Scorton, 9 Lime Tree Close, East Preston, BN16 1JA

EP/52/18/PL

Demolition of existing dwelling & the erection of 7No. residential dwellings, with associated parking, amended access location from Lime Tree Close & landscaping.

Response to objections V4: Lime Tree Close, East Preston. Application number EP/52/18/PL

The Pure Group
Limetree Close East Preston
Plot 5 & 6: Limetree Cottages. Proposed Elevations, Floor Plans, Roof Plan & Section
Drawn by: AM The Pure Group
Drawing ref: LTC.PLOT5&6.001
Planning Issue: March 2018. Scale as Bar
www.thepuregroup.info

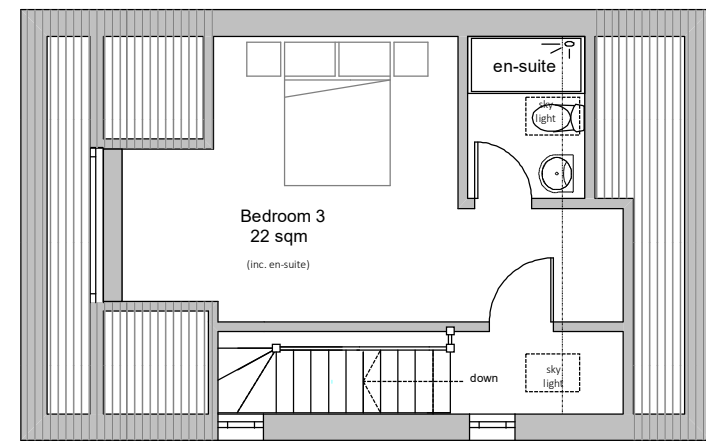
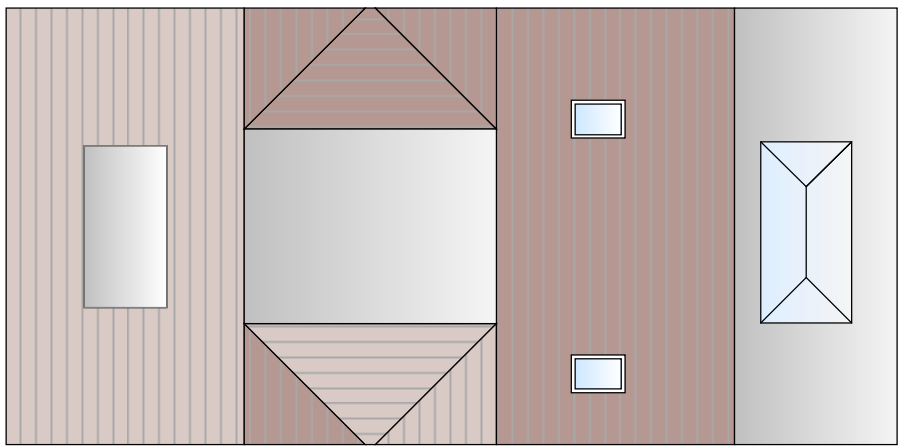
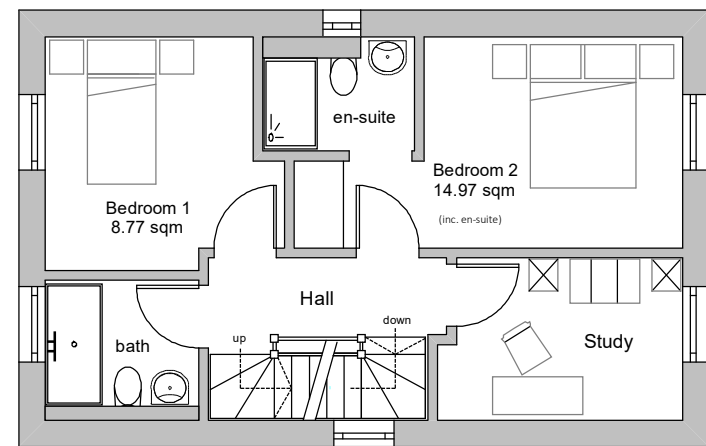
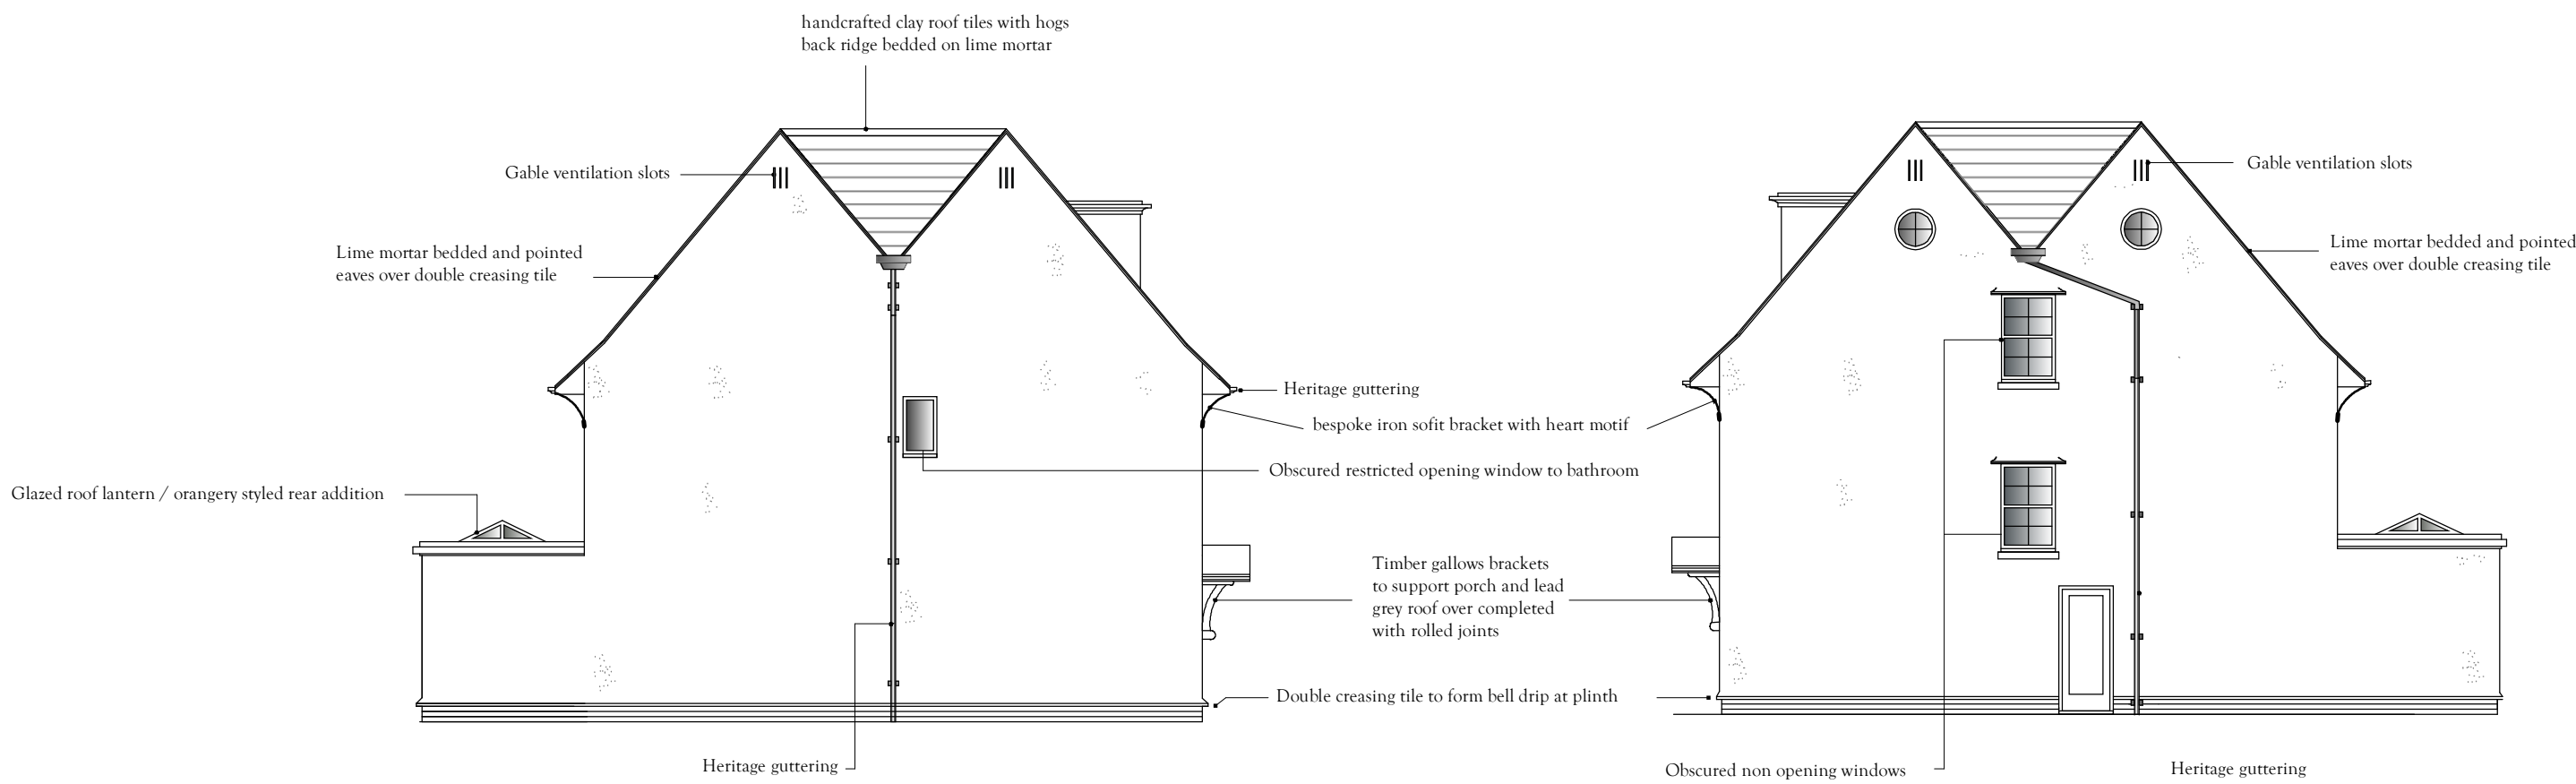
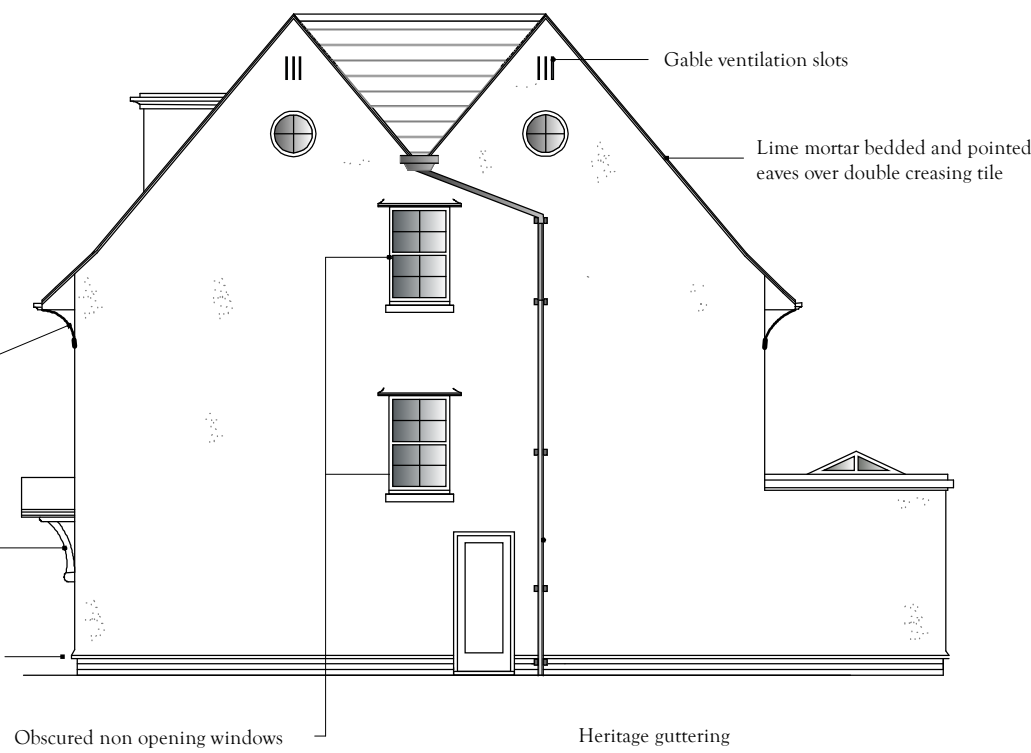
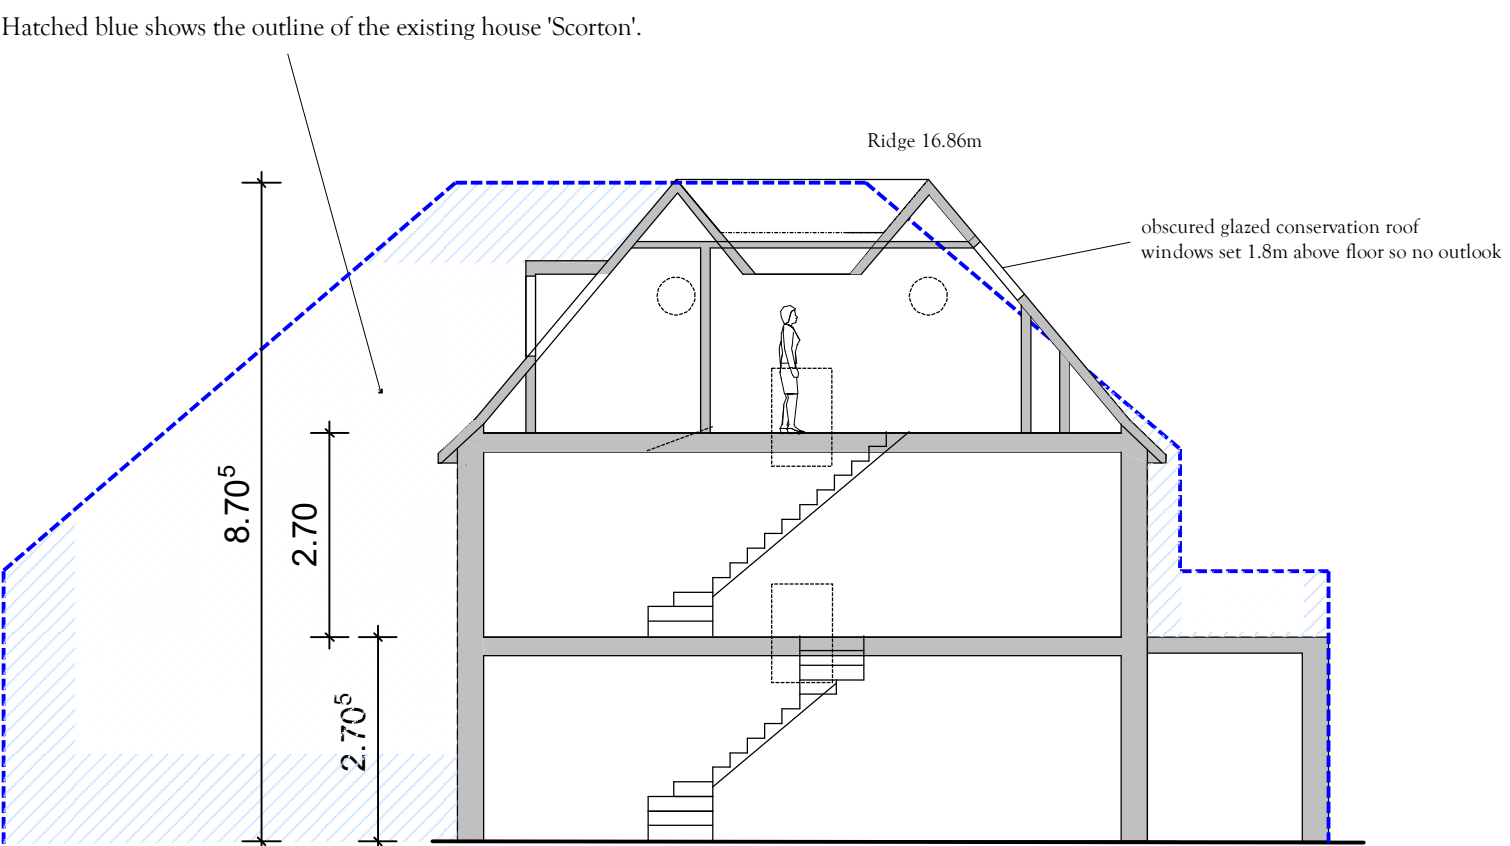
Amendments: East facing roof lights removed

The Pure Group
Limetree Close East Preston
Plot 4: Limetree Cottages. Proposed Elevations, Floor Plans, Roof Plan & Section
Drawn by: AM The Pure Group
Drawing ref: LTC.PLOT4.001
Planning Issue: March 2018. Scale as Bar
www.thepuregroup.info

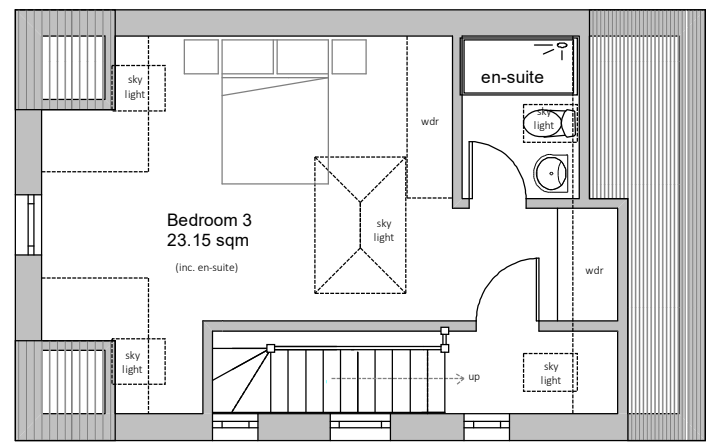
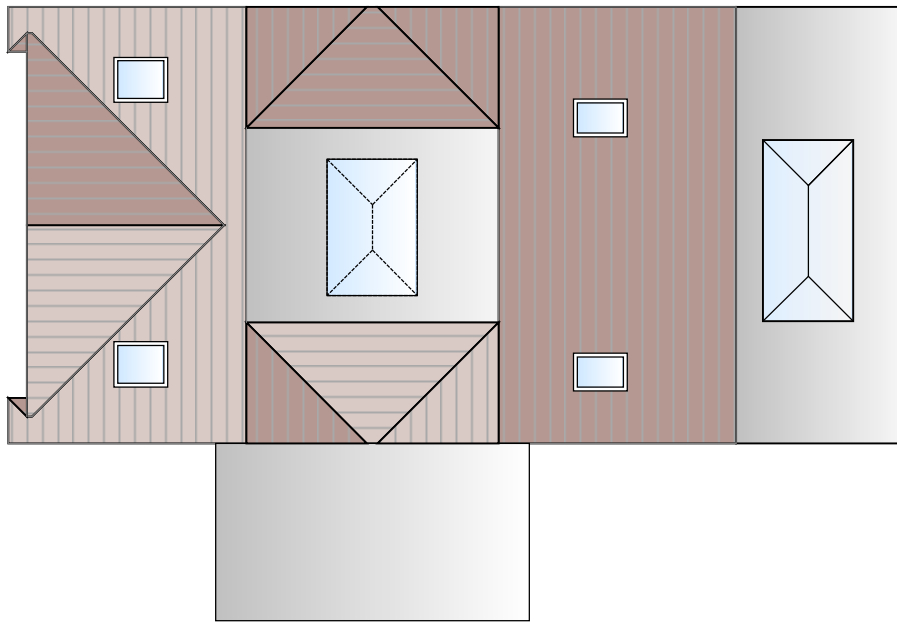
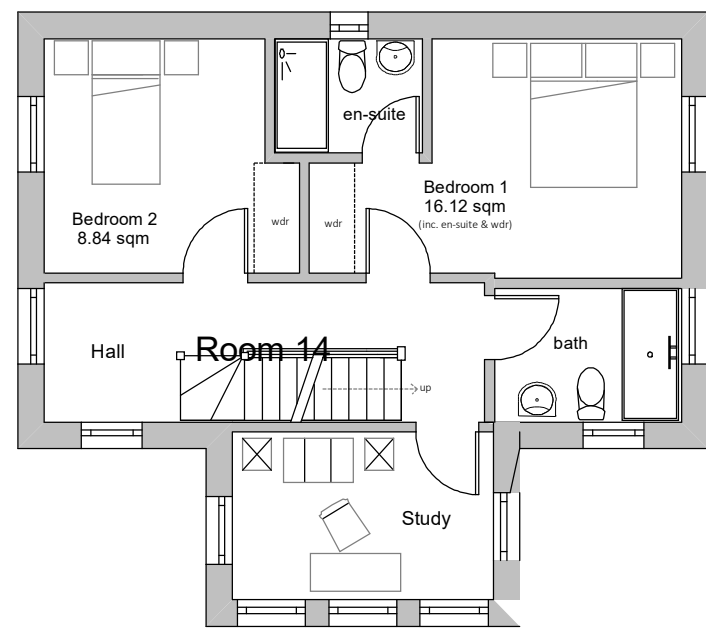
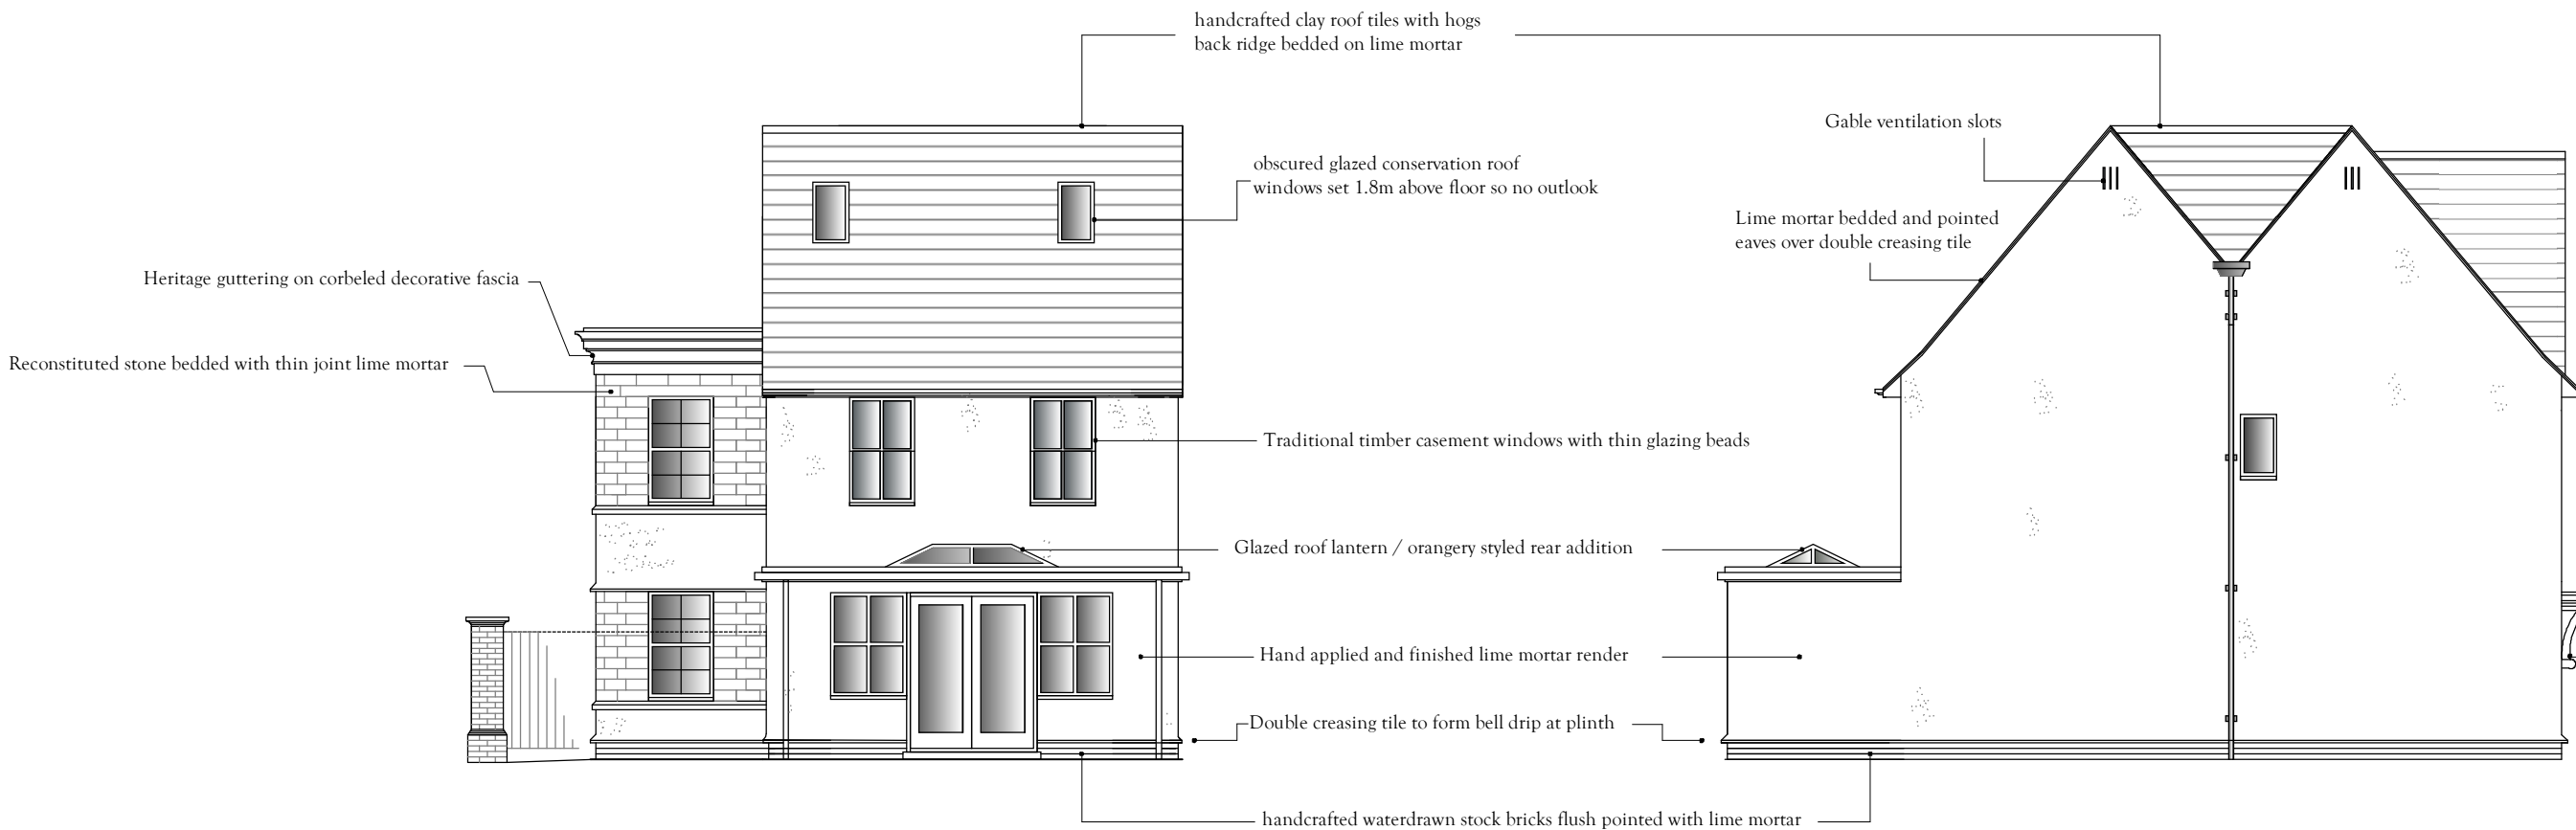
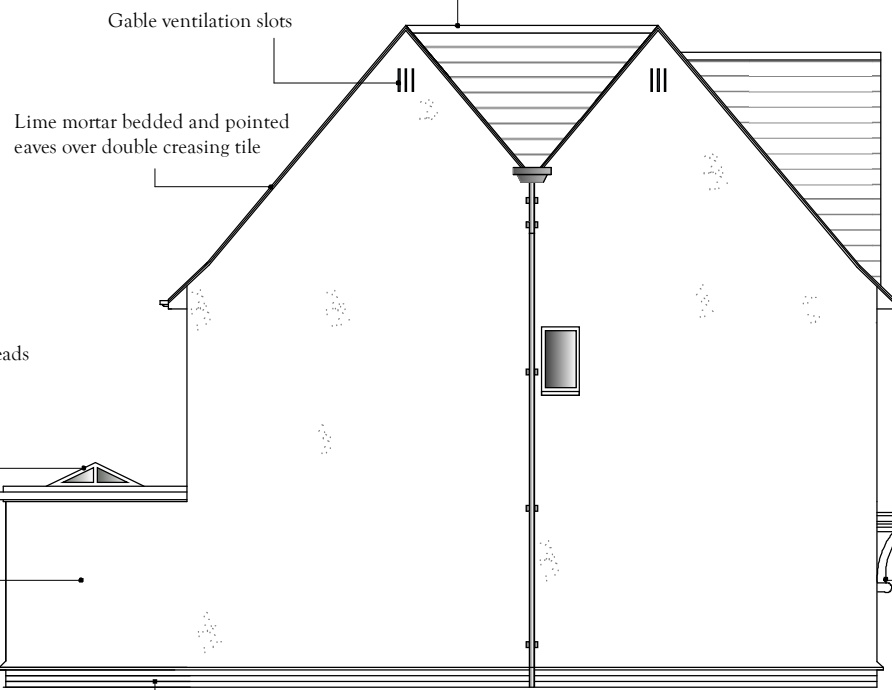
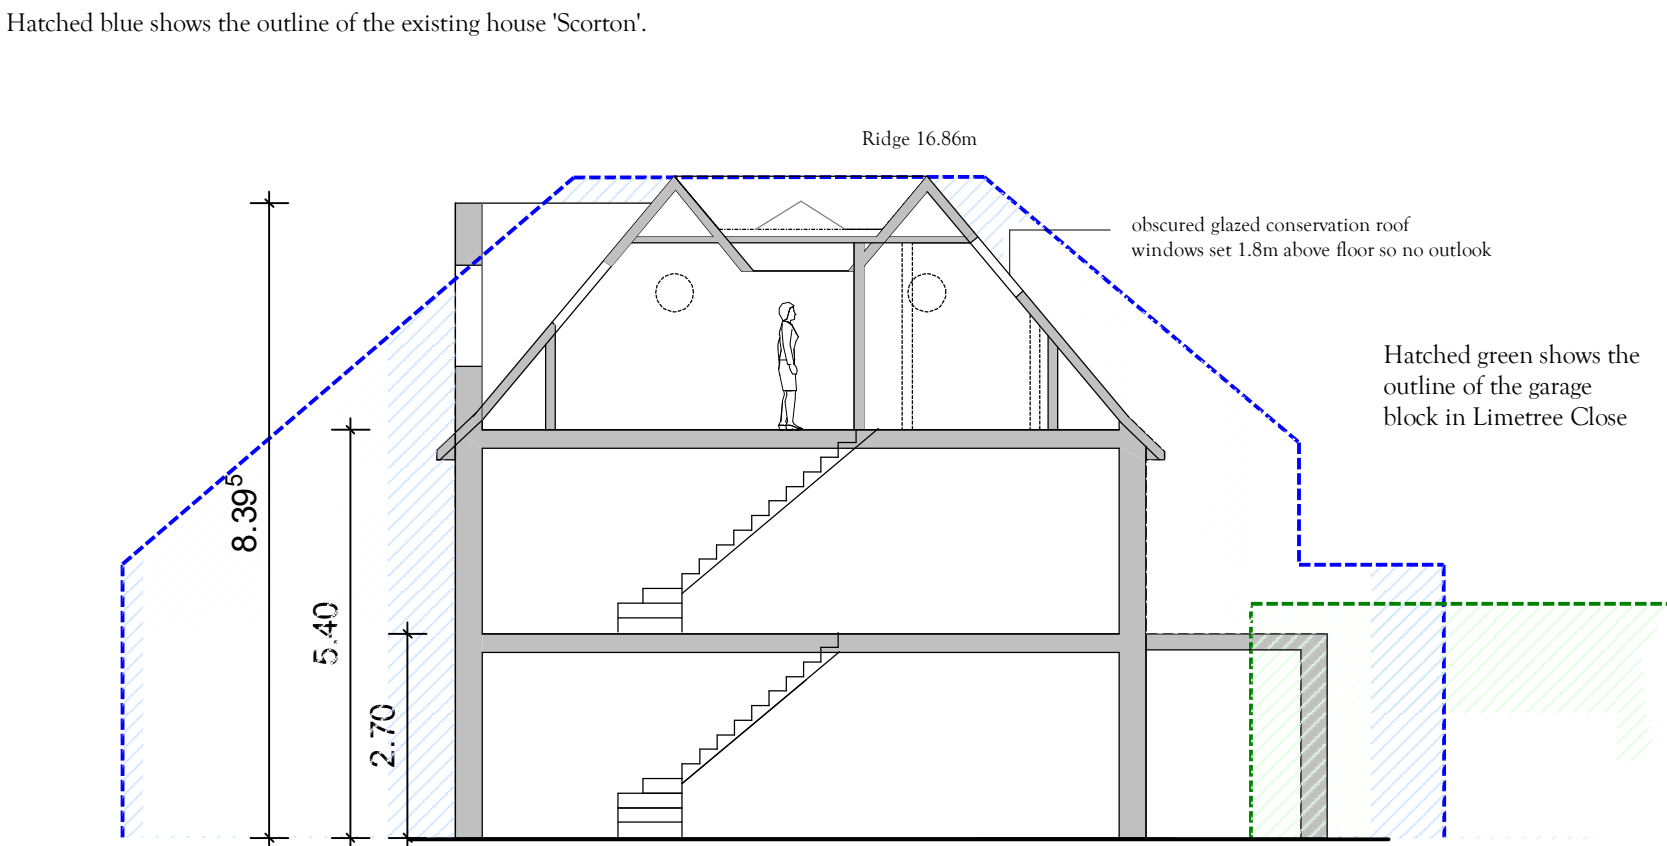
Amendments:
East facing roof lights removed
